Date: 4th March 2024
My Ref: 24/00616/SCO
Your Ref

**Application by Green GEN Cymru (the Applicant) for an Order granting
Development Consent for the Green GEN Vyrnwy Frankton Project (the
Proposed Development)**

**Scoping consultation and notification of the Applicant's contact details and
duty to make available information to the Applicant if requested**

**Figure 3.1: Proposed Tower Type**

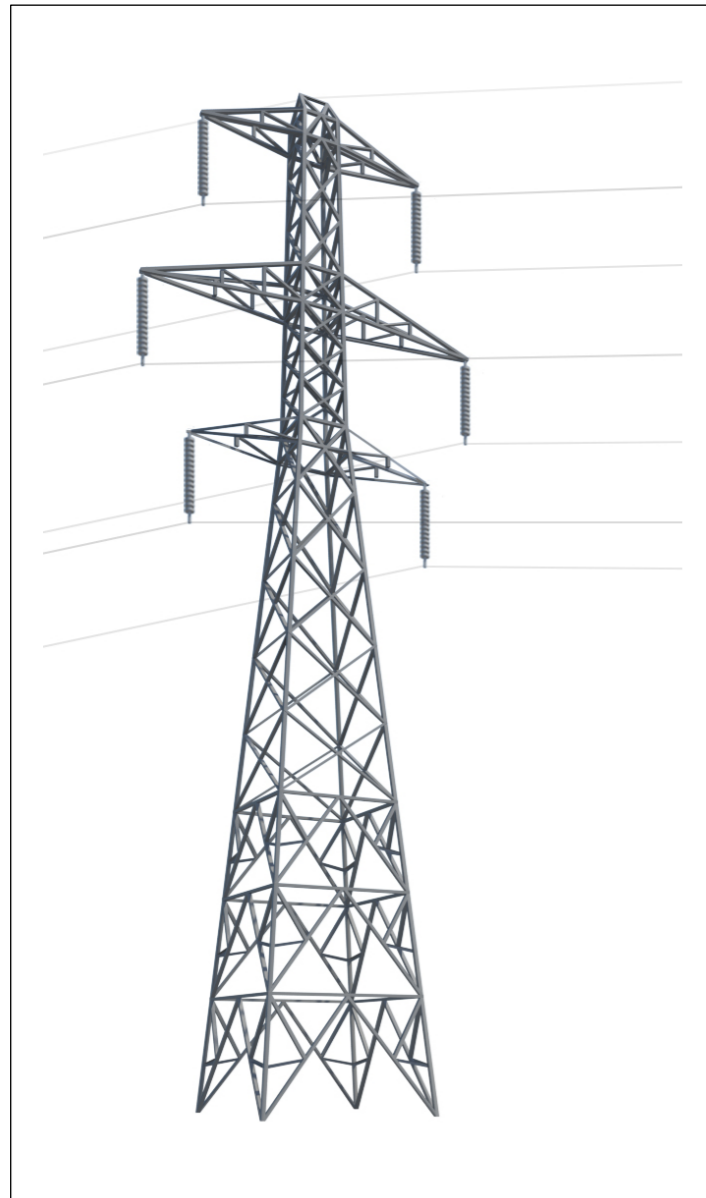
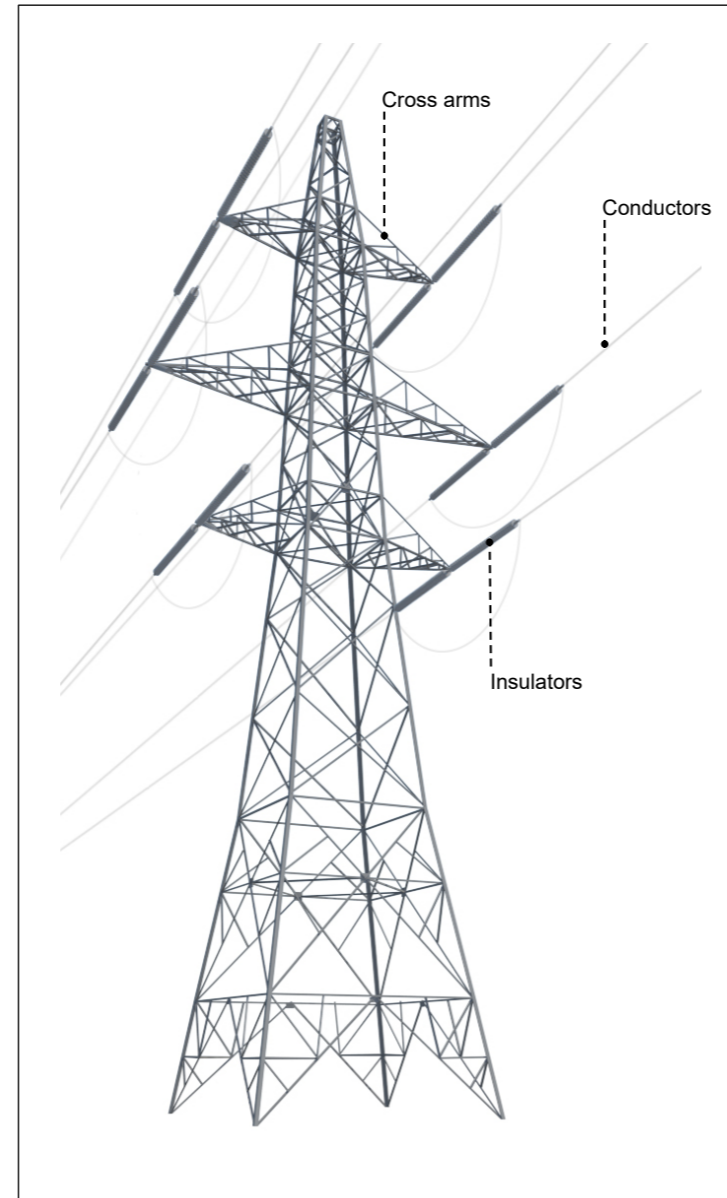
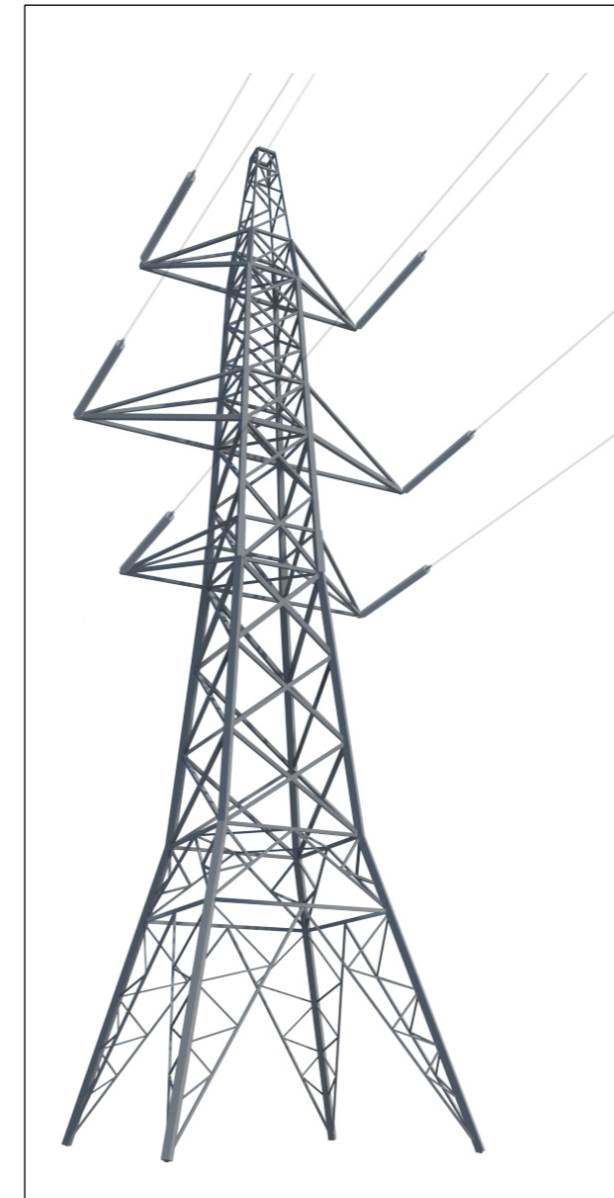
The Scoping Report provides details of 'overhead line infrastructure'. We understand from the Green GEN Grid Connection Strategy document that there are a number of different structures available to support OHL conductor wires with the ability to operate at 132kv. The type of structure proposed would clearly have a significant bearing on the overall potential impacts of the scheme. For example, there may be benefits in providing wooden poles in preference to the traditional lattices structures from a landscape and visual perspective. Consideration should be given at an early stage of the process as to whether alternative designs should be incorporated within the project in order to avoid or minimise adverse impacts. In addition the assessment of alternatives should include an appropriate level of detail as to alternative designs, and the relative environmental effect of these.

Figure 7.9: Visual Receptors and Preliminary Viewpoints - Page 1 of 2

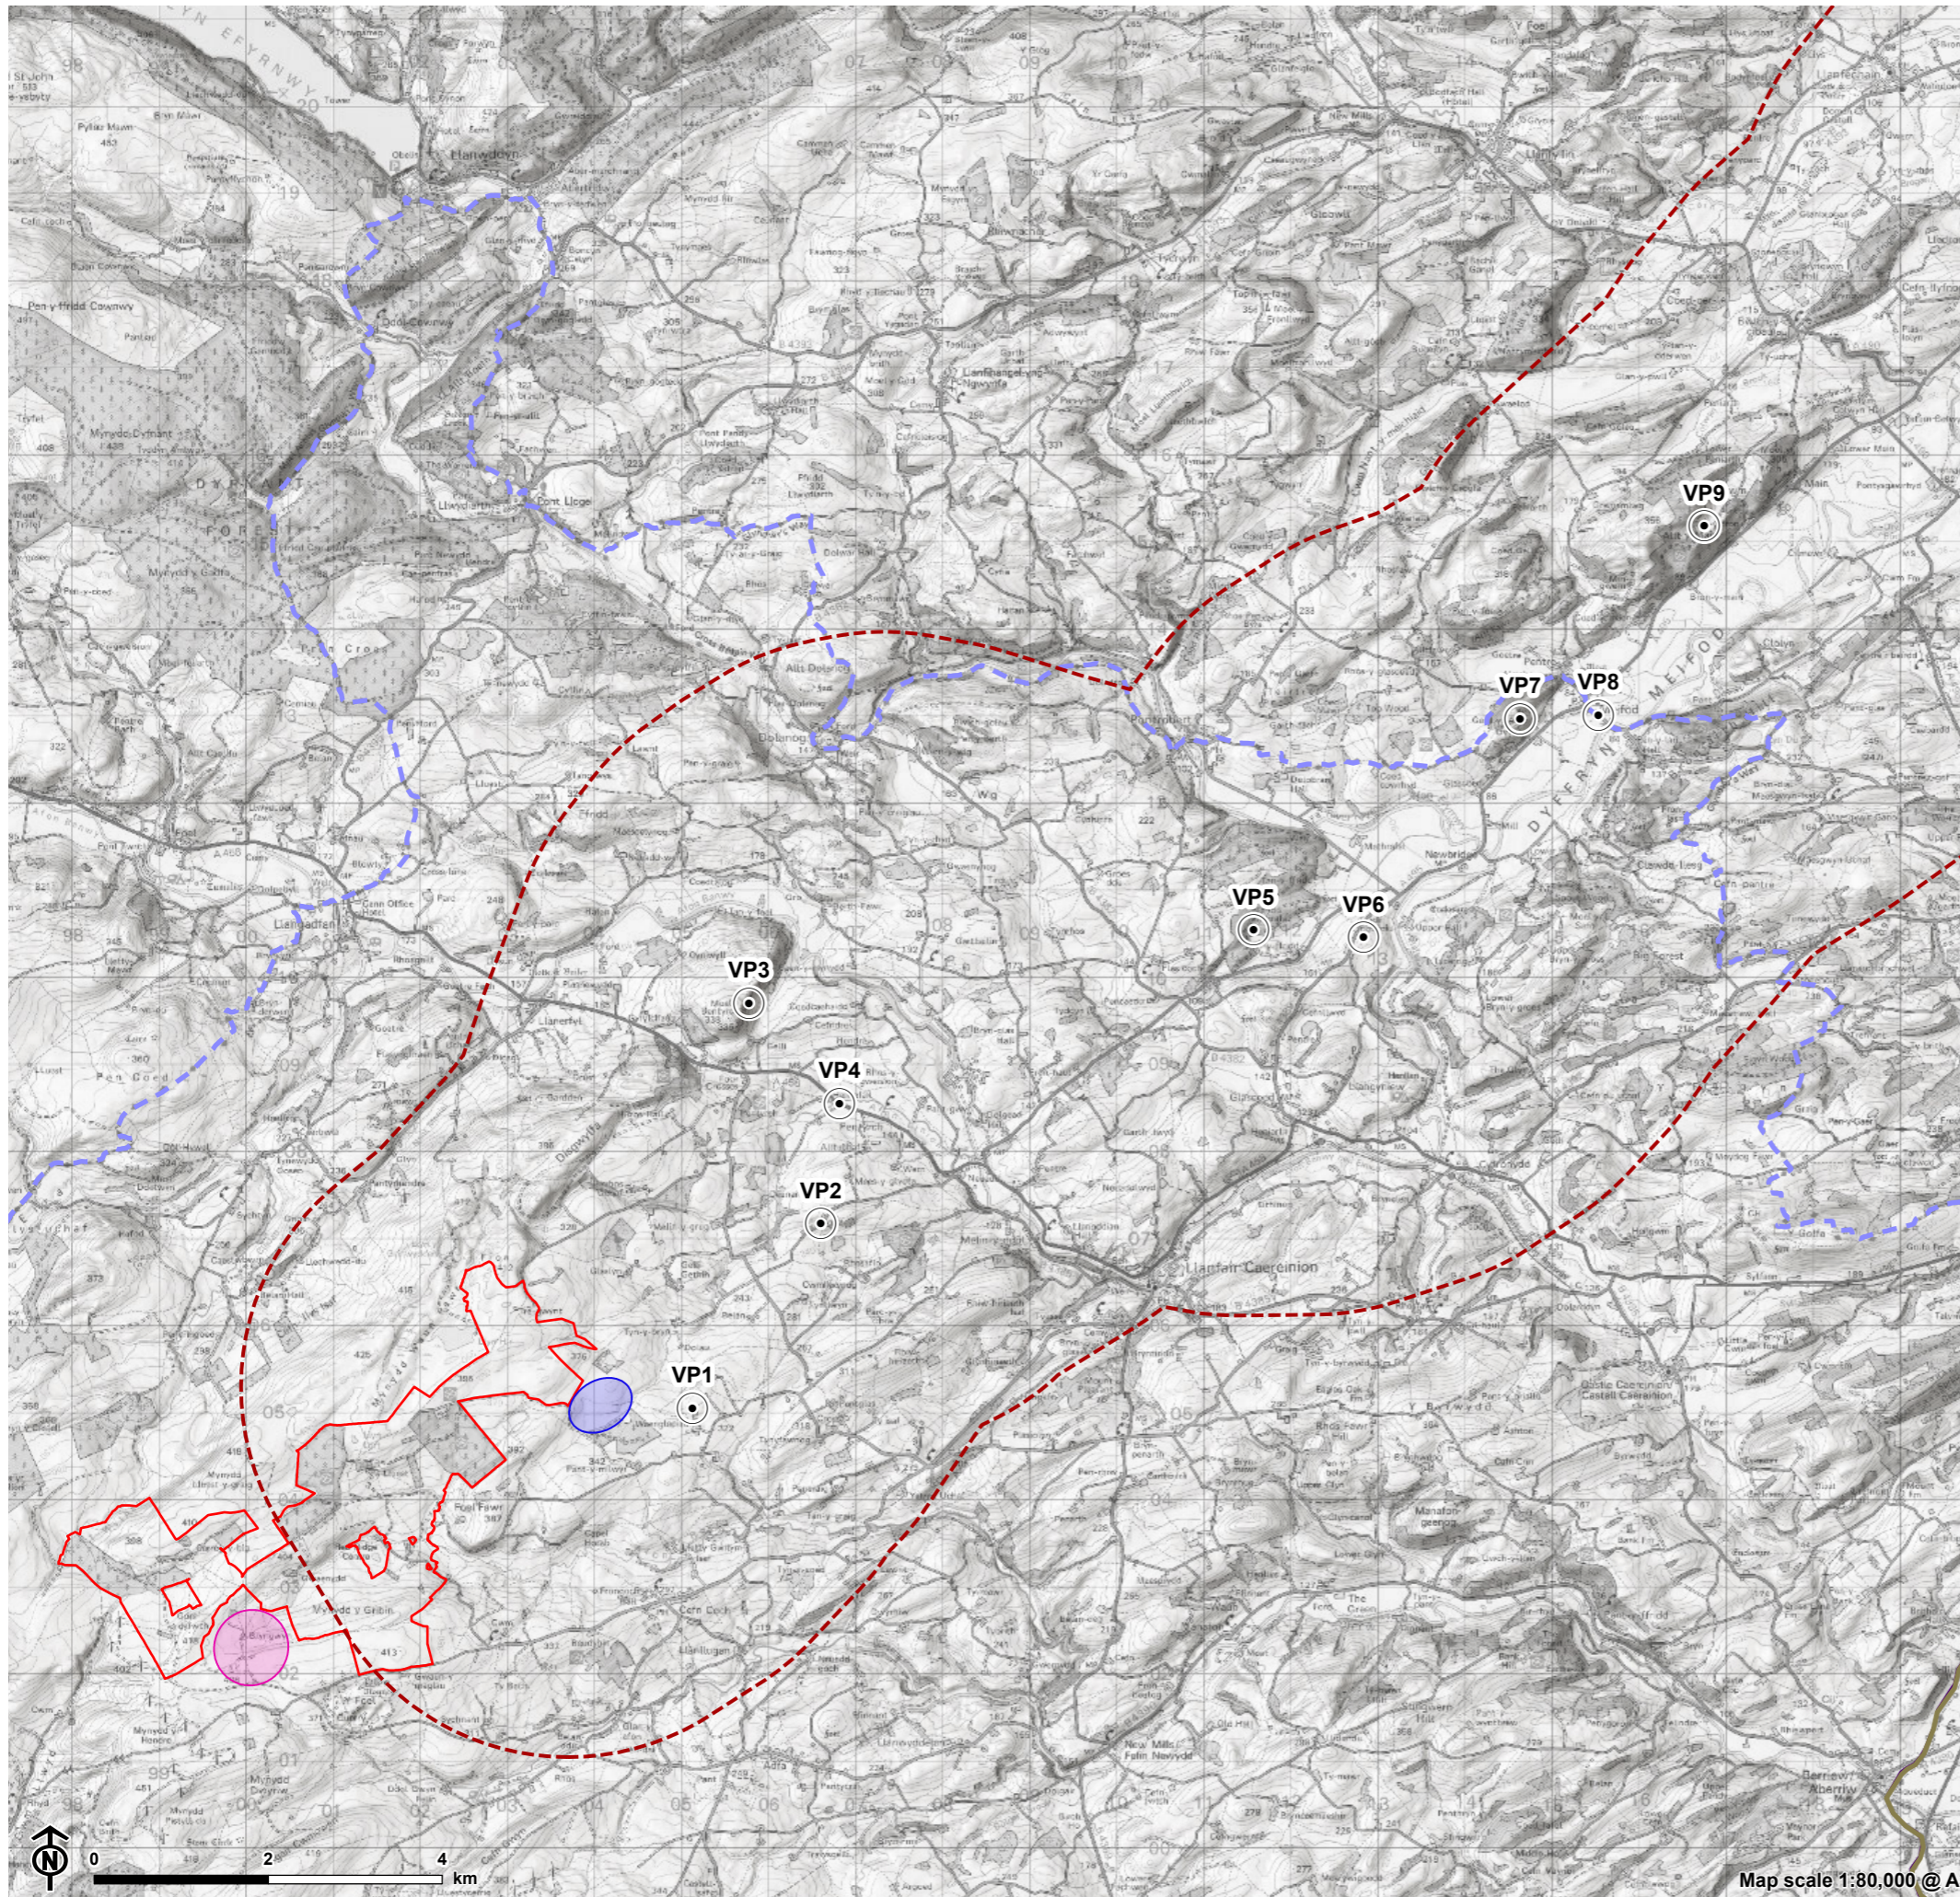
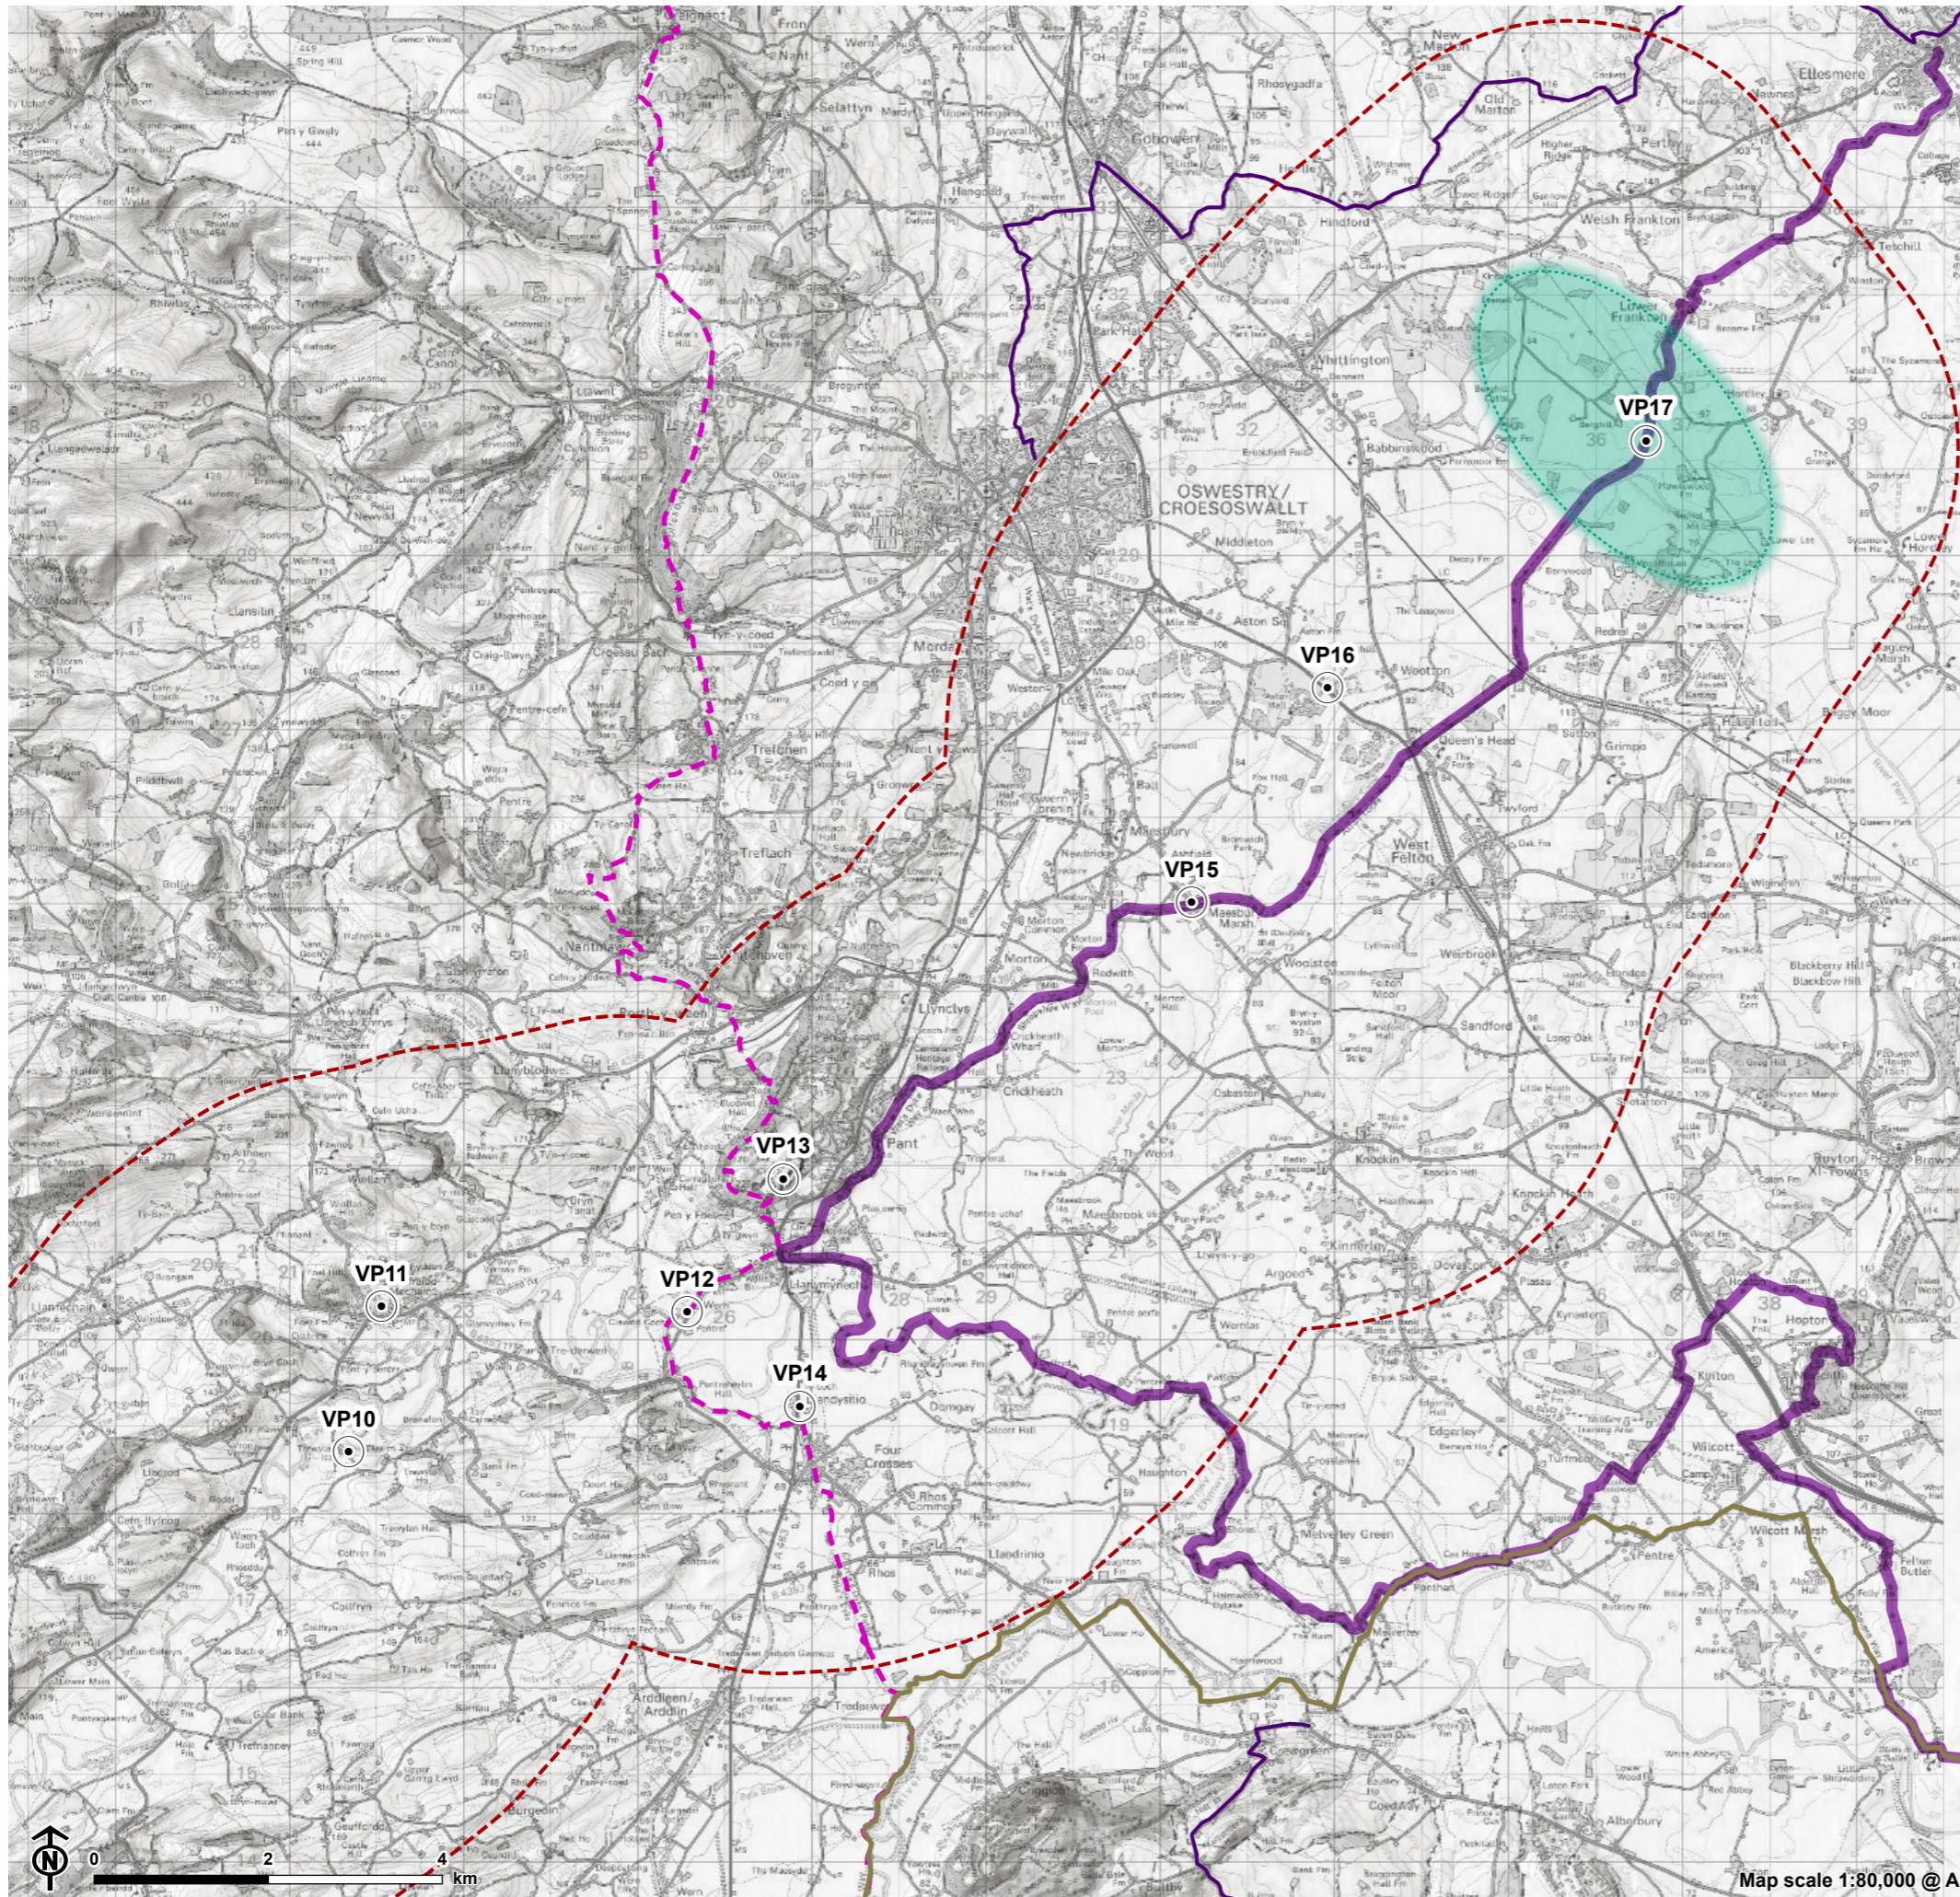
Reference to Figure 7.9 indicates that three viewpoints are currently proposed within Shropshire. Paragraphs 7.25 and 7.39 indicate that the preliminary list of viewpoints will be expanded/refined following ZTV analysis of the final proposed route and commits to further consultation with consultees (including Shropshire Council) on the final viewpoint locations. This is welcomed. We recommend that the type of visualisation (photomontage/wireline) proposed for each viewpoint also be agreed with consultees as part of future consultation.
